REQUEST

Current Zoning: B-1SCD (shopping center district, conditional)
Proposed Zoning: CAC-1(CD) (community activity center-1, conditional)

Approximately 1.98 acres along the west side of Carmel Road, north of Carmel Commons Boulevard, and south of Pineville-Matthews Road.

The petition proposes the development of up to 38 multi-family attached dwelling units. The site is currently developed with a surface parking lot.

SITE PLAN

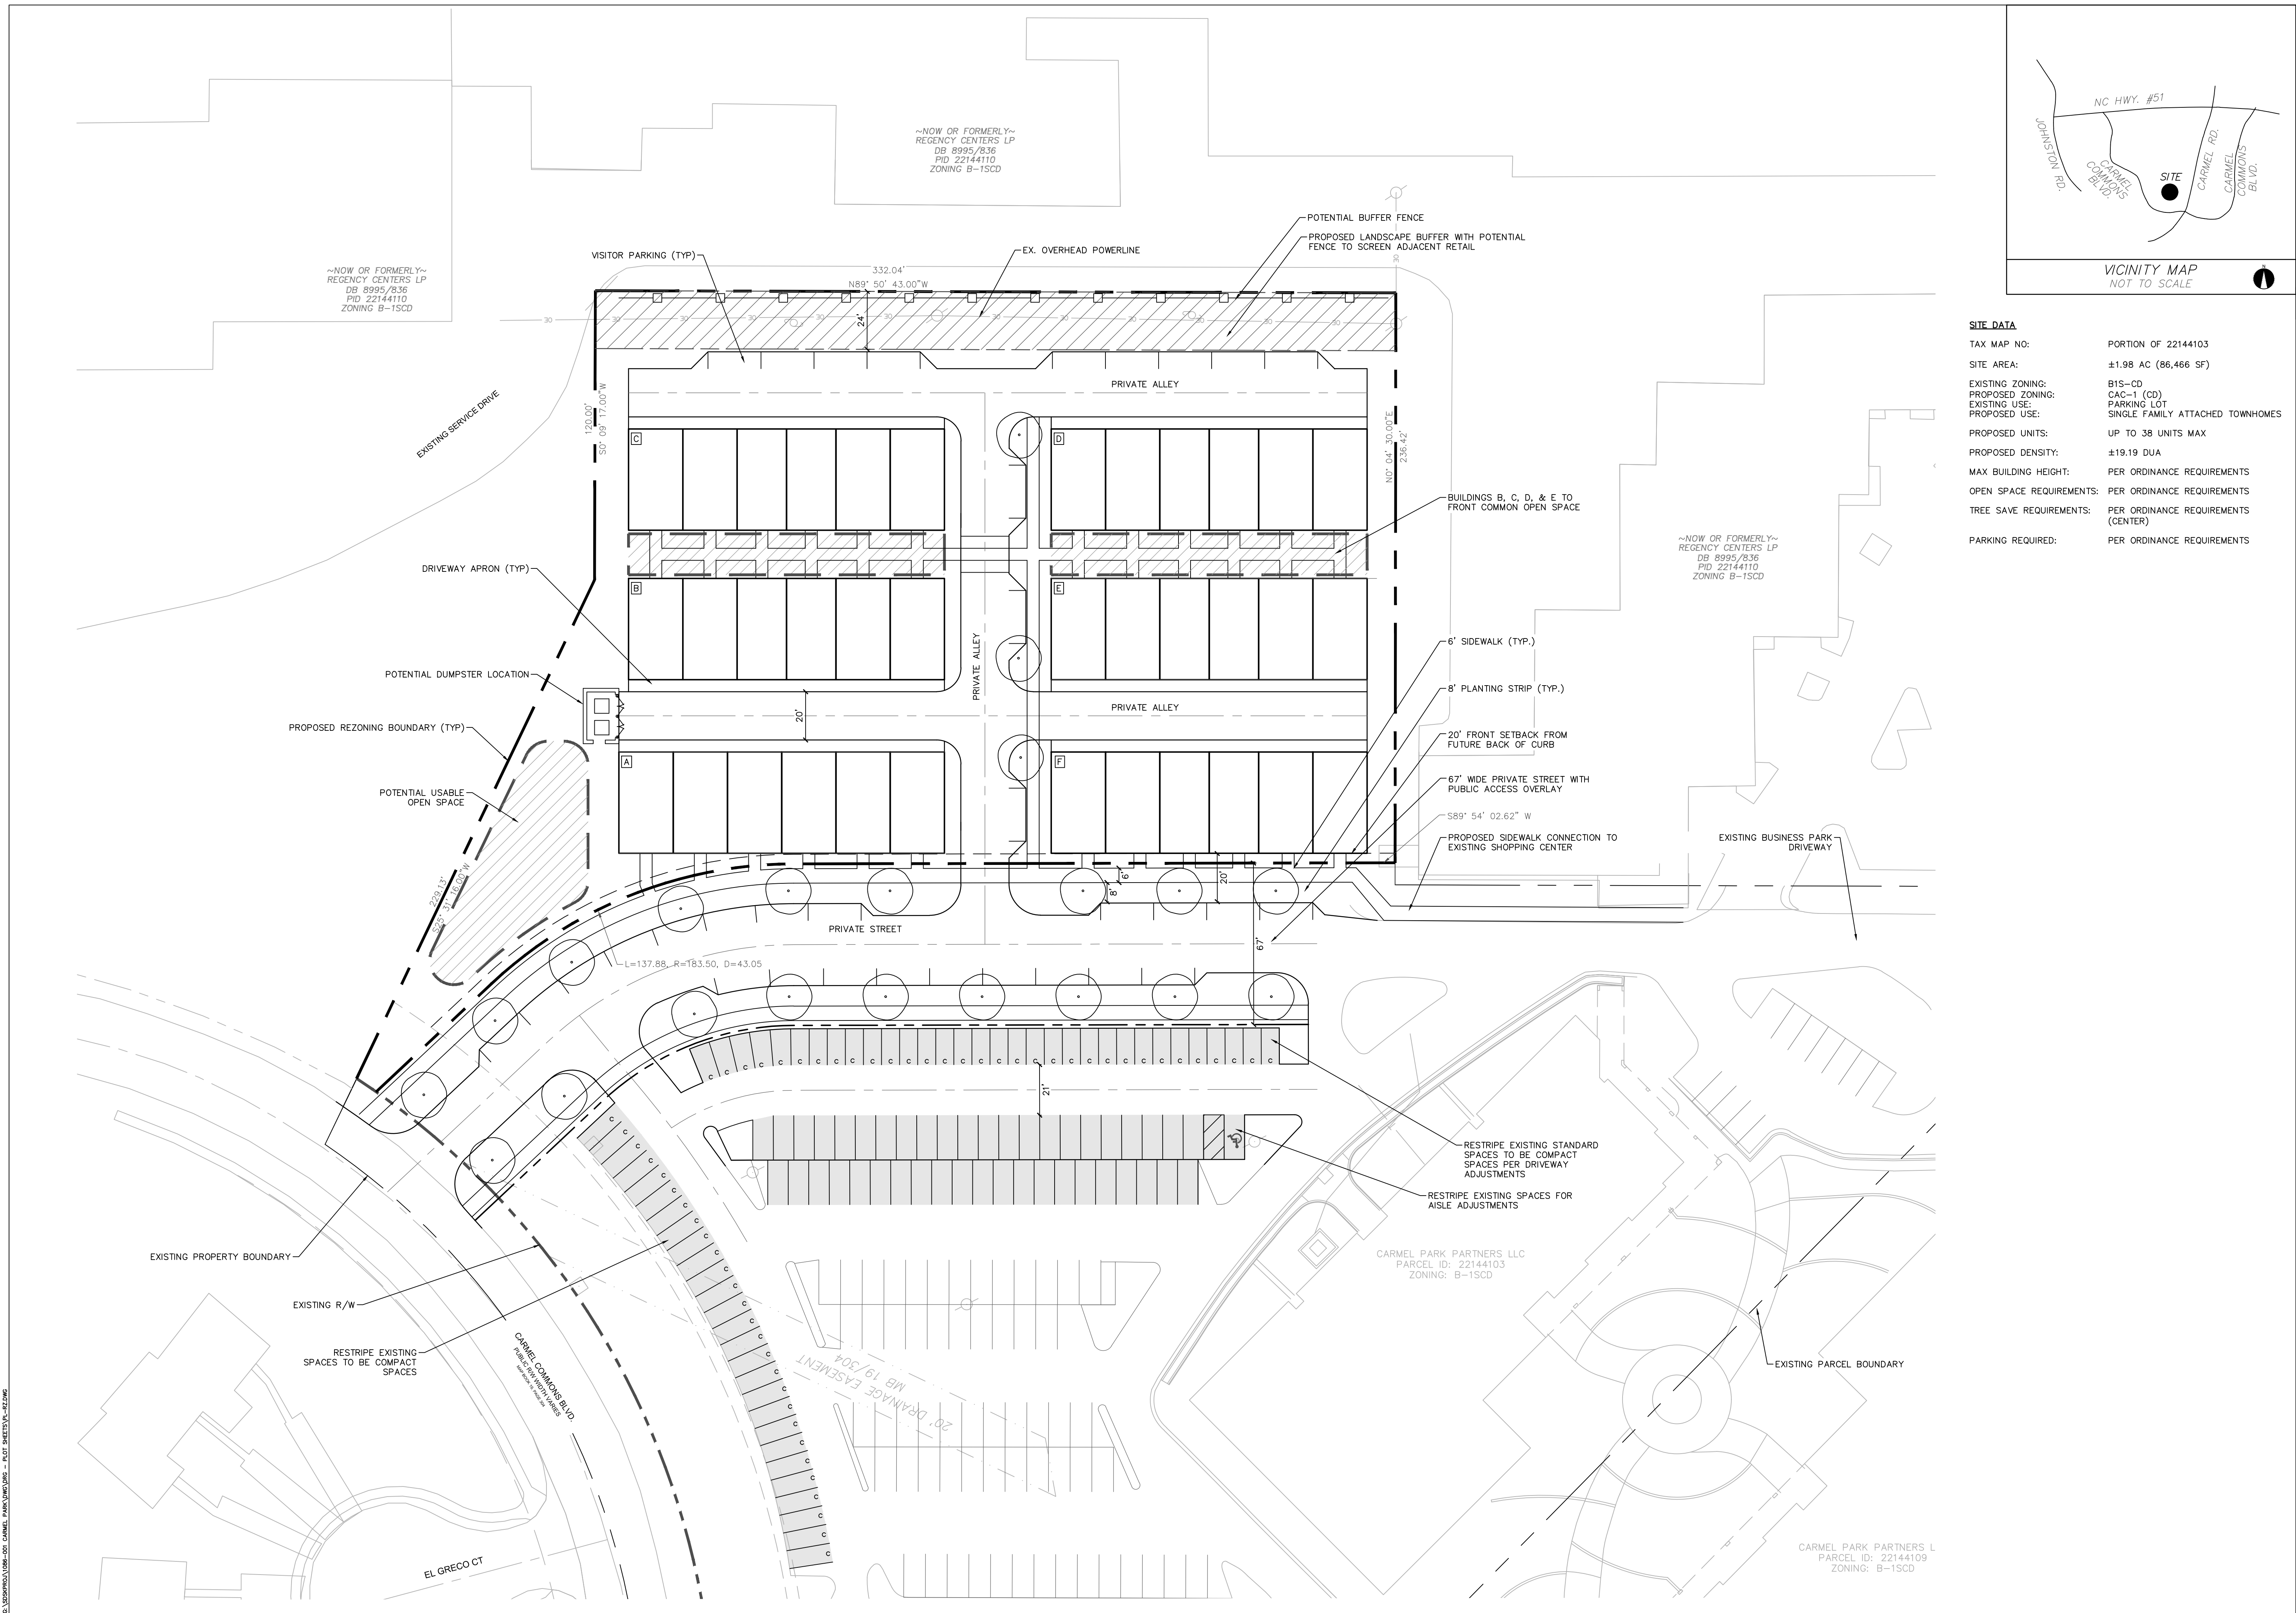
1. ~~Entitlement Services: a berm along the rear (north) property line should be included to replace the existing berm and better screen the development from the shopping center.~~ **Addressed**
2. ~~Entitlement Services: a minimum number and maximum spacing trees to be planted along internal alleys should be include.~~ **Addressed**
3. ~~Entitlement Services: Note regarding existing parking count, and how this development will impact the prior B-1SCD rezoning plan's parking requirements, should be clarified.~~ **Addressed**

4. ~~Entitlement Services: Maximum building height is stated as 50 feet site data table and 52 feet in conditional notes. Please rectify.~~ **Addressed**
5. ~~Entitlement Services: Revise boundaries of rezoning to include proposed improvement to private street.~~ **Addressed**
